Please upload the two attached drainage drawings together with the surface water network document onto Ocella for planning application **A/76/20/PL**.

1. Catchment area plan to enable verification of provided calculations, preferably in dwg format. (I know you gave the overall impermeable areas, it would just be good to see this broken down to verify that you have taken all of the bits that you need to into account)
2. Cross sections of attenuation basin, detailing offset of basin to surrounding features, including adjacent ordinary watercourse. An unobstructed 3m buffer should be provided around the attenuation basin. (These can be quite rough, just need to see top of bank of each feature shown really at this stage, this also facilitates my review of the attenuation volume provided)
3. Flotation calculations demonstrating that a safe basin design can be achieved in the given footprint and provide the required free volume for water storage.

Date	Drawing No.	Rev.
November 2019	D1260-PL300	C

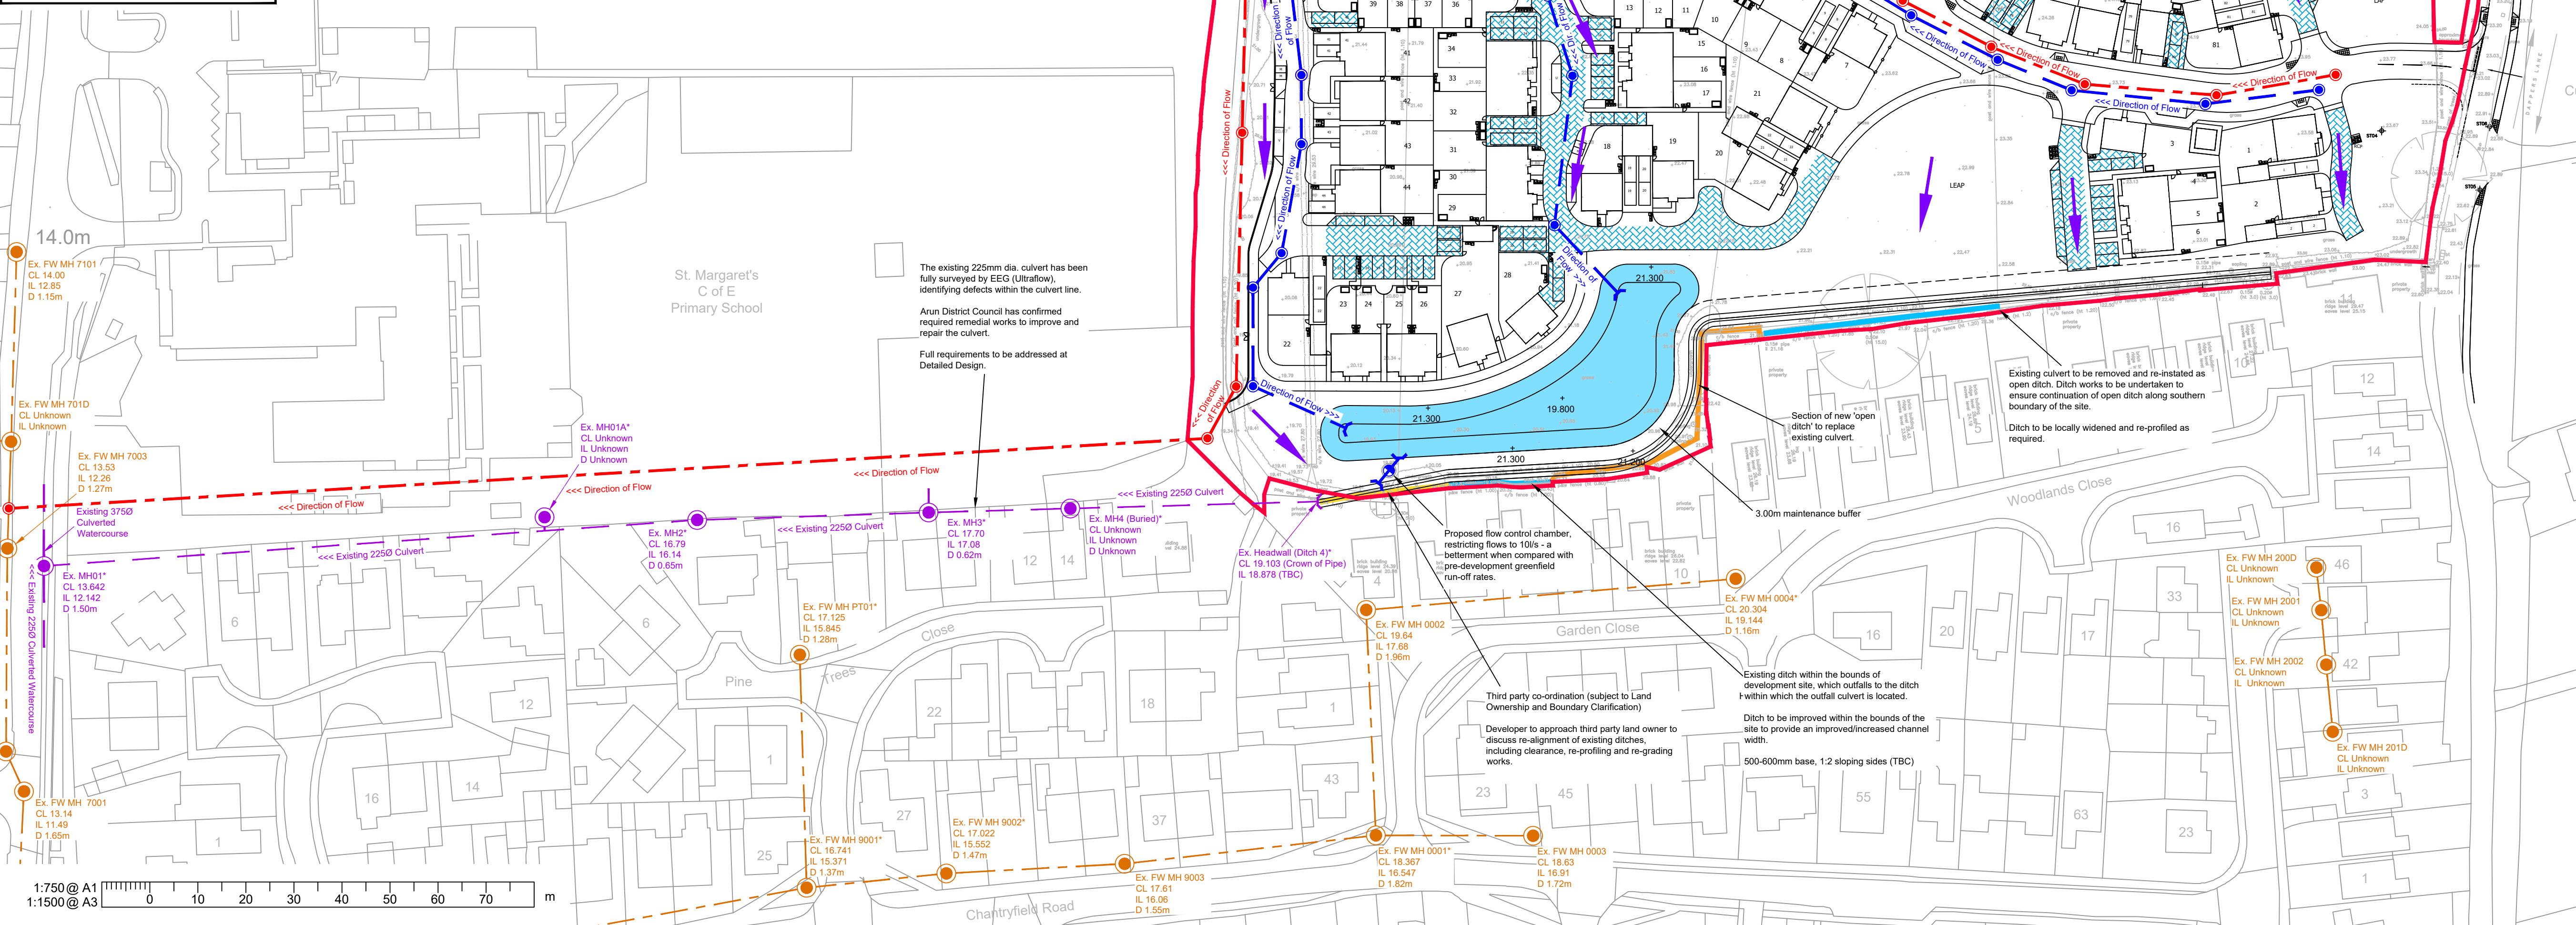
2. Cross sections of attenuation basin, detailing offset of basin to surrounding features, including adjacent ordinary watercourse. An unobstructed 3m buffer should be provided around the attenuation basin. There is a buffer around the pond of at least 3.00m, with the exception of to the south of the pond where it is slightly reduced owing to the re-grading works associated with the watercourse. This has not been detailed out at present, and is a point for detailed design. It is demonstrated, however, that the pond can be maintained with the buffer that is provided in all other areas.

5. evidence that a 3m buffer is provided throughout the site to the southern watercourse (N.B. 3m is measured from the top of bank of watercourse). As mentioned above, where the watercourse passes adjacent to the pond along the southern boundary, it is not possible to provide a 3.00m buffer – it is slightly reduced here. As we move past the pond (to the west towards the outfall location where the culvert is located) it opens back up again. Essentially, we have a 'pinch point' by the pond.
